From: Holly Duncan
Sent: Monday, April 23, 2012 11:06 AM
To: Jeff Watson
Subject: RE: BL-12-00006 Dewalt

From: Jeff Watson
Sent: Tuesday, April 17, 2012 3:54 PM
To: Christina Wollman; Brenda Larsen; Jan Ollivier; Holly Duncan
Subject: BL-12-00006 Dewalt

[BL-12-00006 Dewalt](#)

PART OF THE SOUTHWEST QUARTER OF SECTION 28,
TOWNSHIP 20 NORTH, RANGE 17 EAST, W.M.

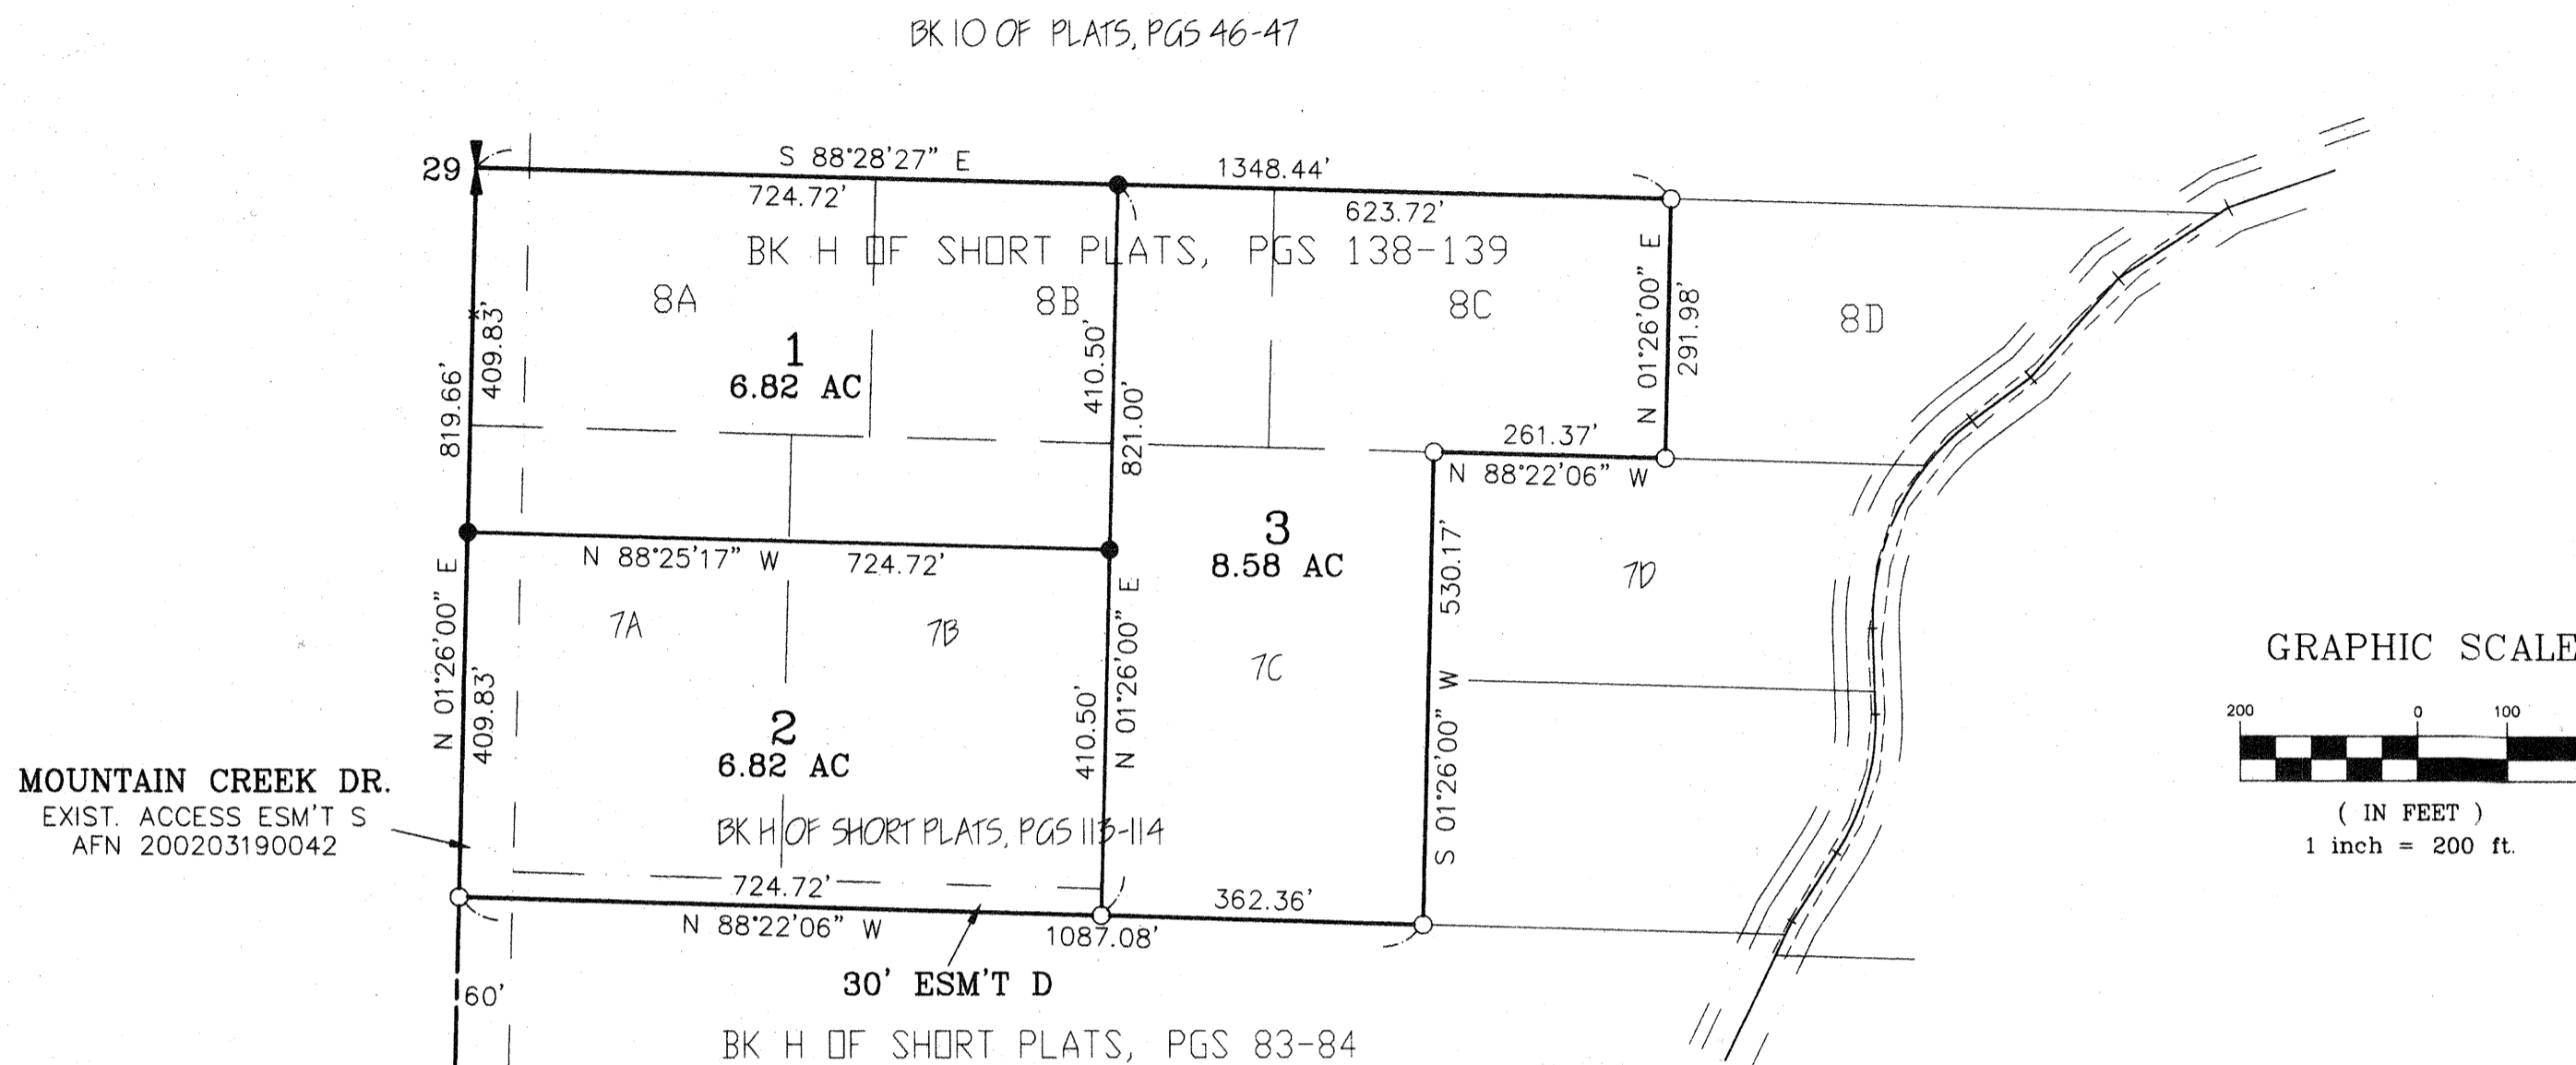
If there are no existing wells on the lots that would be within 50 feet of the proposed lines this will be no problem.
